Our ref: DOC19/722863
Senders ref: SSD-10154

Subject: EES comments on Response to Submissions for Qantas Flight Training Centre – SSD-10154 – 297 King Street, Mascot

Subject: EES comments on Response to Submissions – Qantas Flight Training Centre – SSD-10154 – 297 King Street Mascot

- Project Site Boundary
- Extent of Works
- +RL 0.00 Proposed nominal design levels (Refer Civil)
- +EX 0.00 Existing level
- Existing 0.1m contour

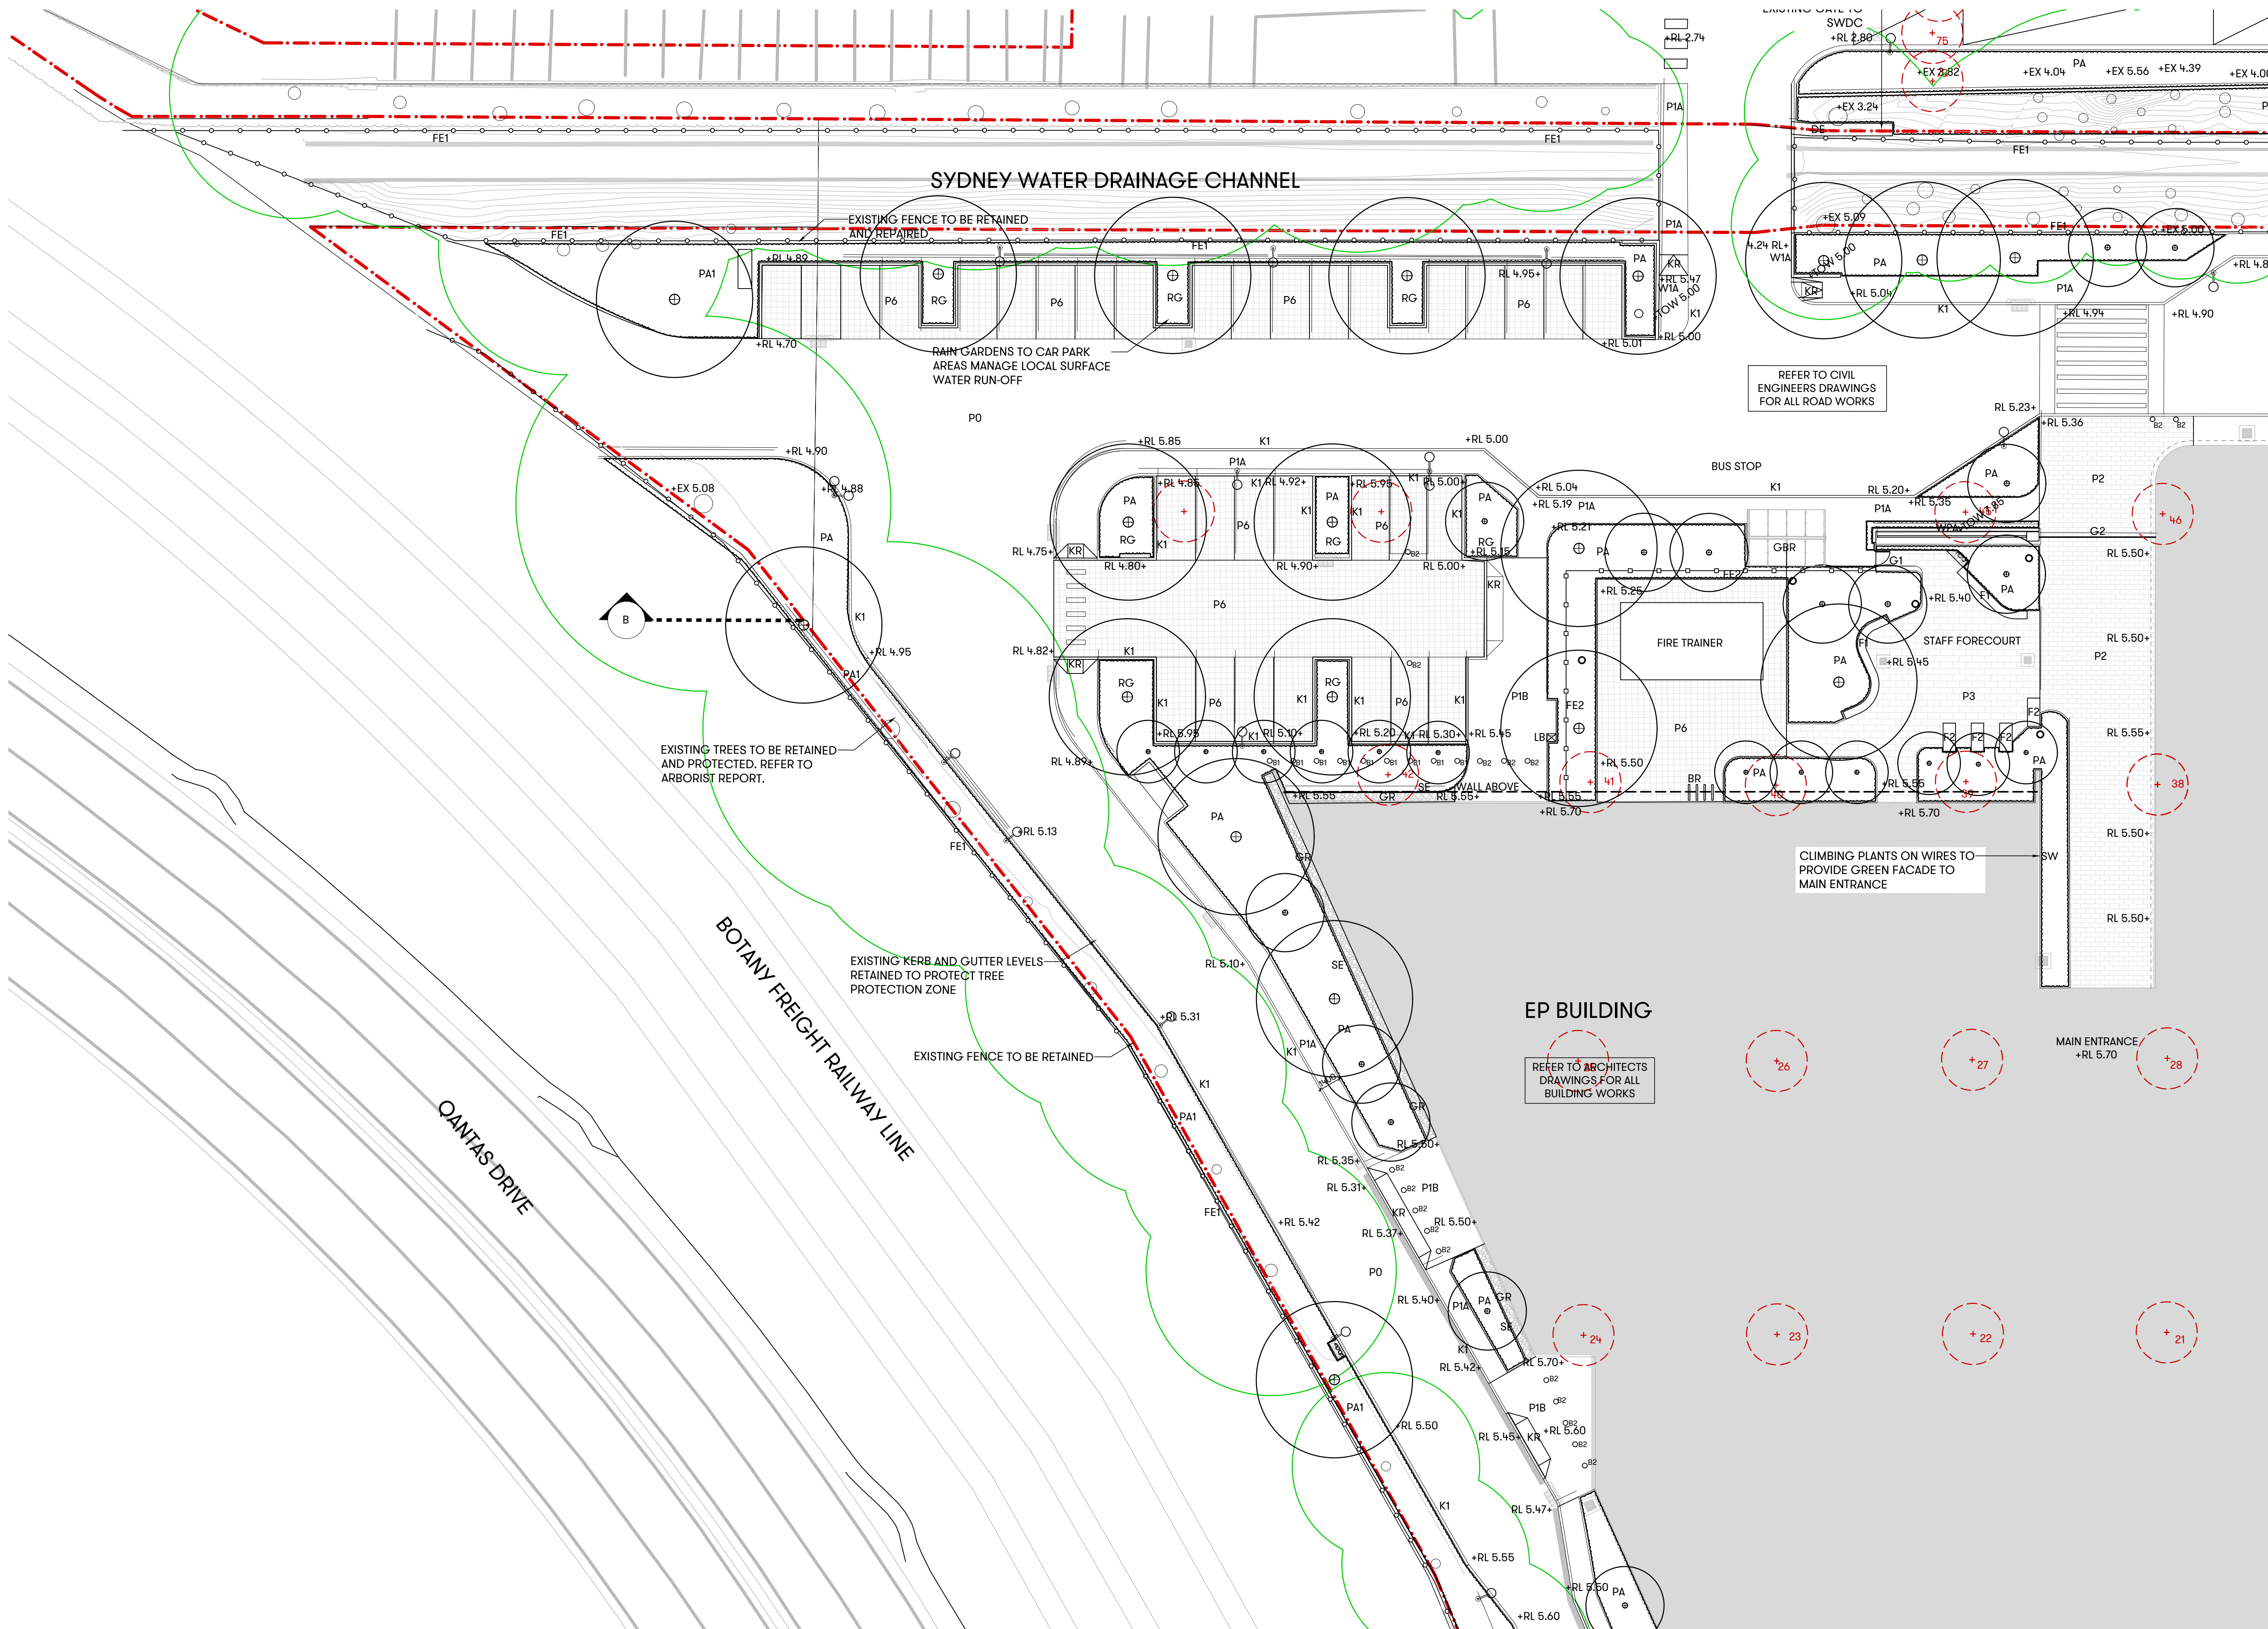
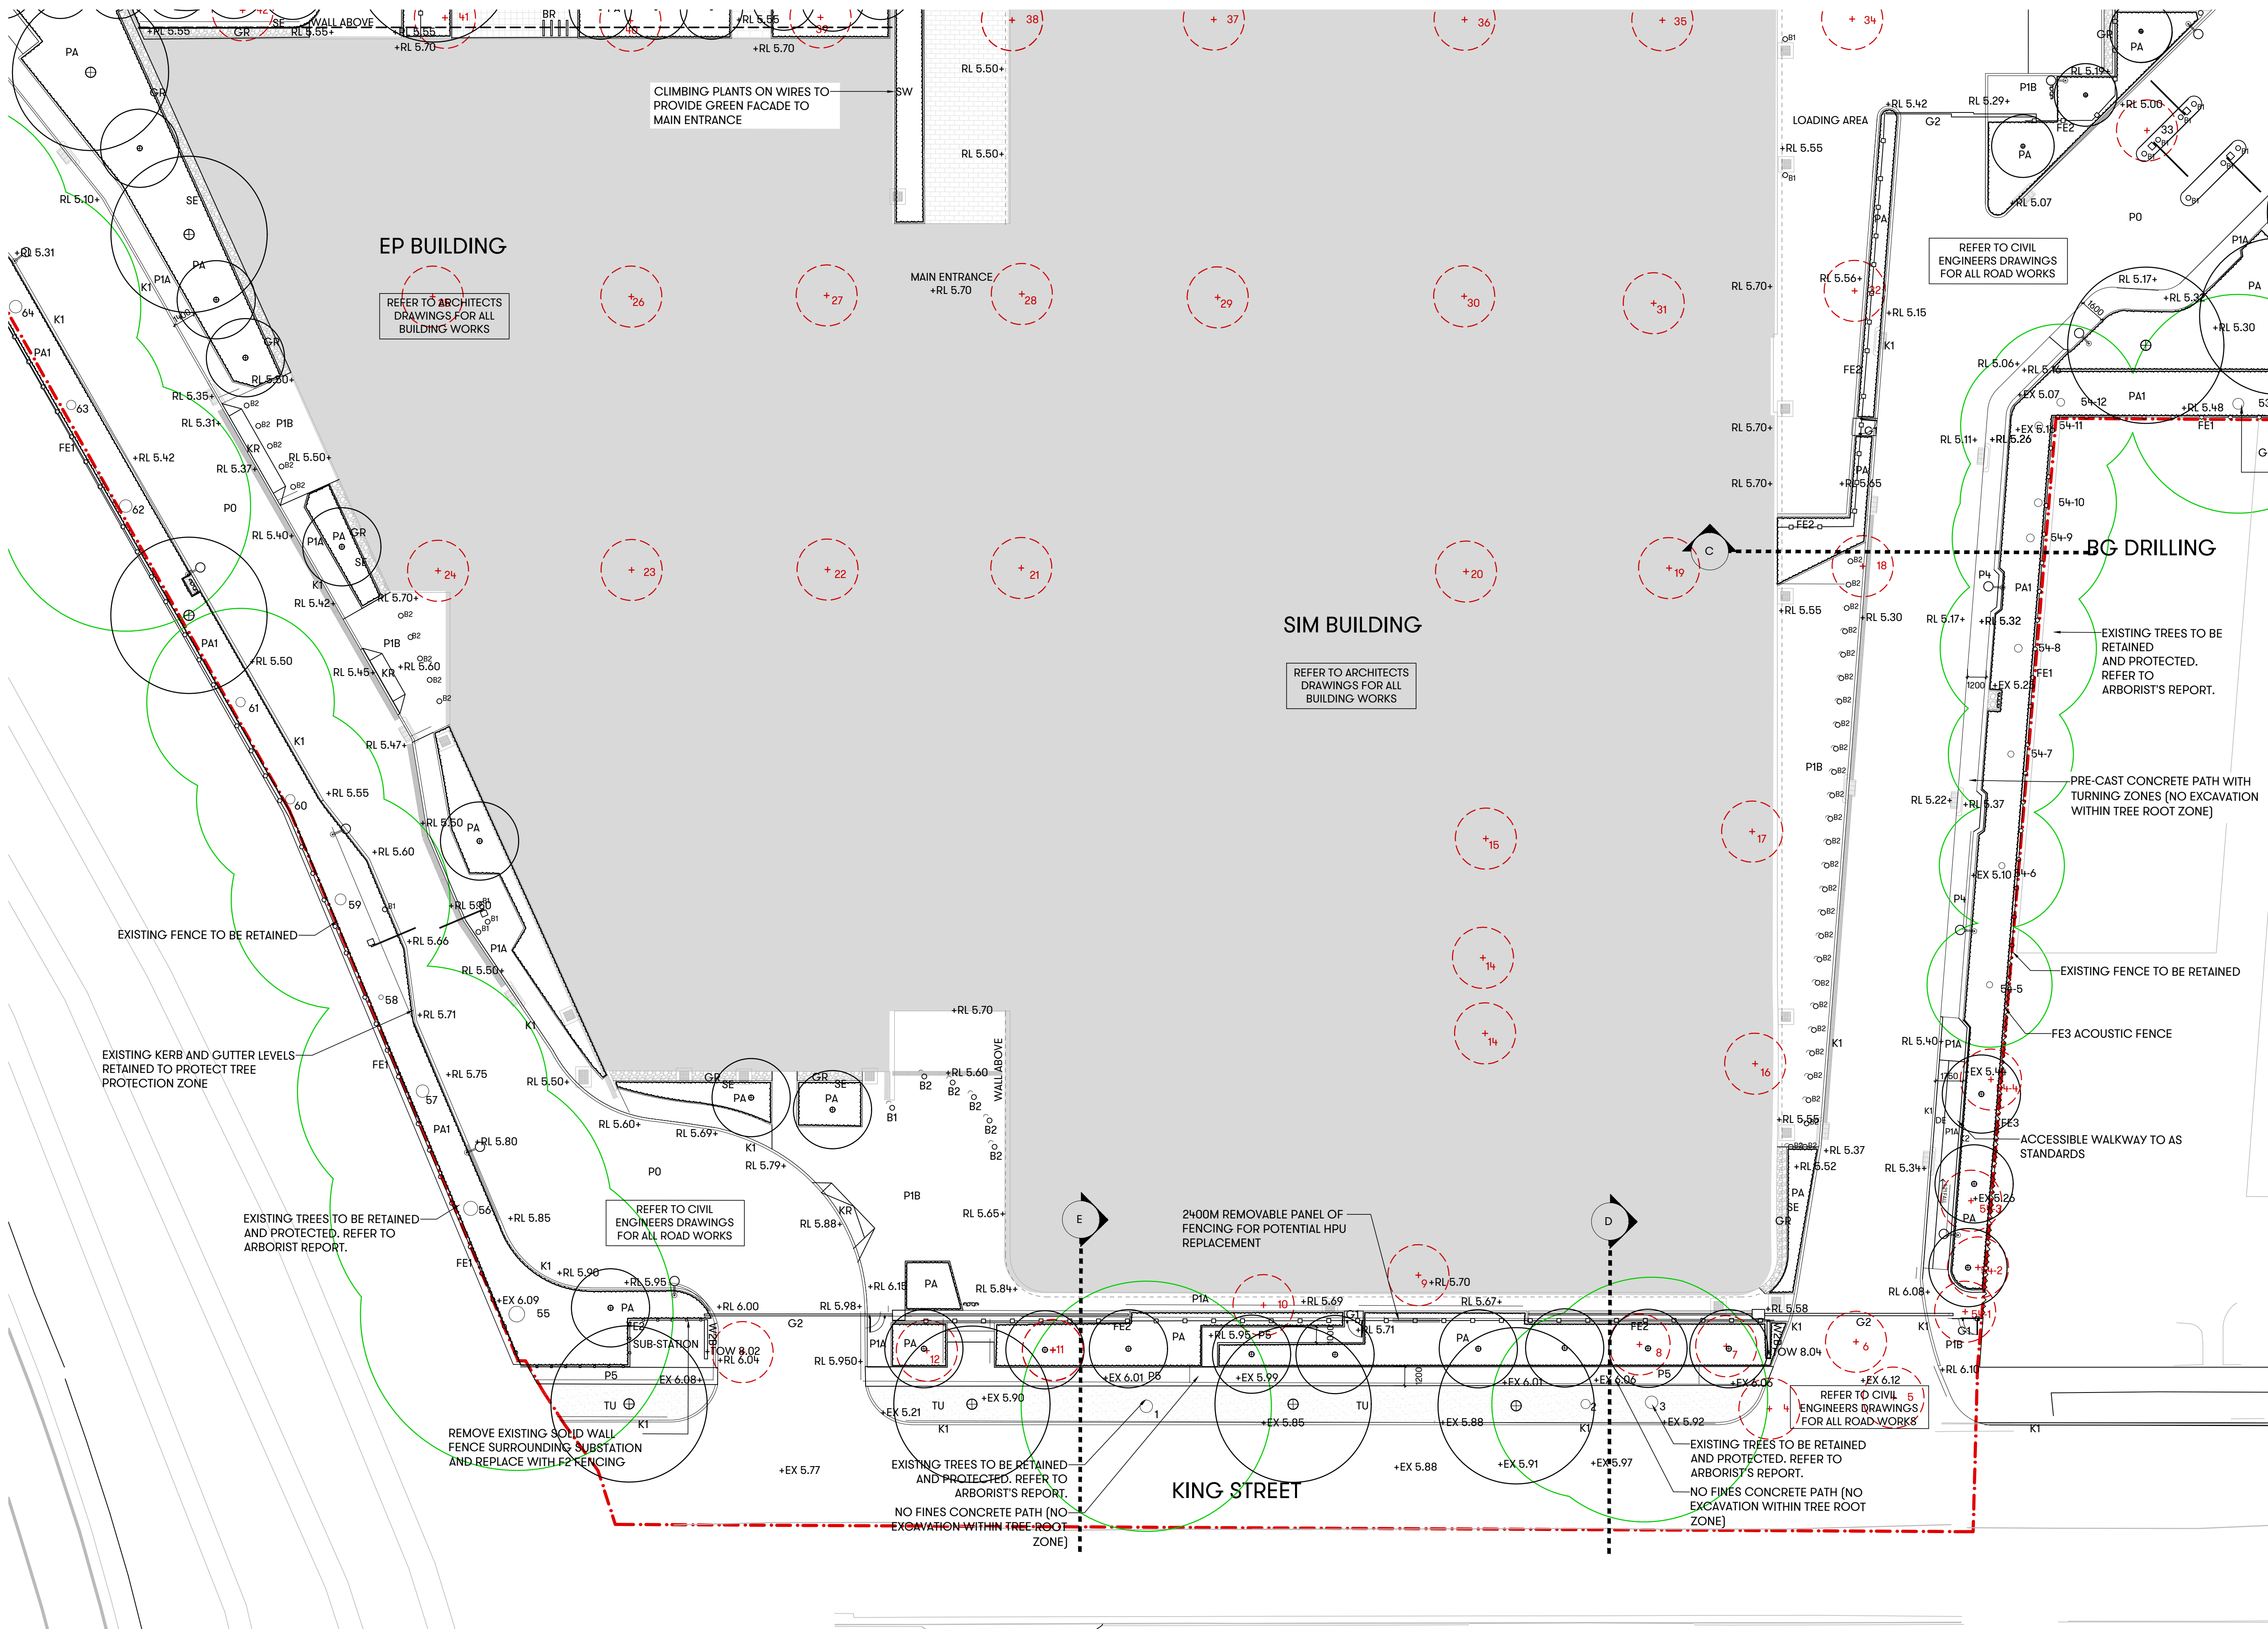
In relation to the first recommendation above that the development first avoids removing the existing trees, it is noted the proposed number of trees to be removed has increased by an additional tree from the removal of 85 trees in the EIS to the removal of 86 trees in the RTS.

In relation to the second recommendation above that any removed trees are replaced at a ratio greater than 1:1, the RTS confirms the landscape plans have been amended to increase the number of replacement trees from 68 trees to 92 trees with a replacement rate of over 1:1 ratio (see pages 2-10, 3-23 and 3-61).

- The RTS notes four *Eucalyptus haemastoma* are proposed to be planted along King street (page 3.34) but the NSW Threatened Species Scientific Committee final determination for ESBS does not list *Eucalyptus haemastoma* as occurring in the ESBS ecological community. Tree species which occur in the ESBS community that could be planted as an alternative include *Angophora costata* and *Corymbia gummifera*.

As the RTS indicates that ESBS once occurred on the site, EES encourages a greater use of ESBS plant species where available. The NSW Threatened Species Scientific Committee final determination for this critically endangered ecological community includes a list of ESBS species: www.environment.nsw.gov.au/resources/threatenedspecies/determinations/FDESBSCEECC.pdf.

- all replacement trees and landscape species will consist of a diversity of local provenance plant species from the Eastern Suburbs Banksia Scrub in the Sydney Bioregion where available.
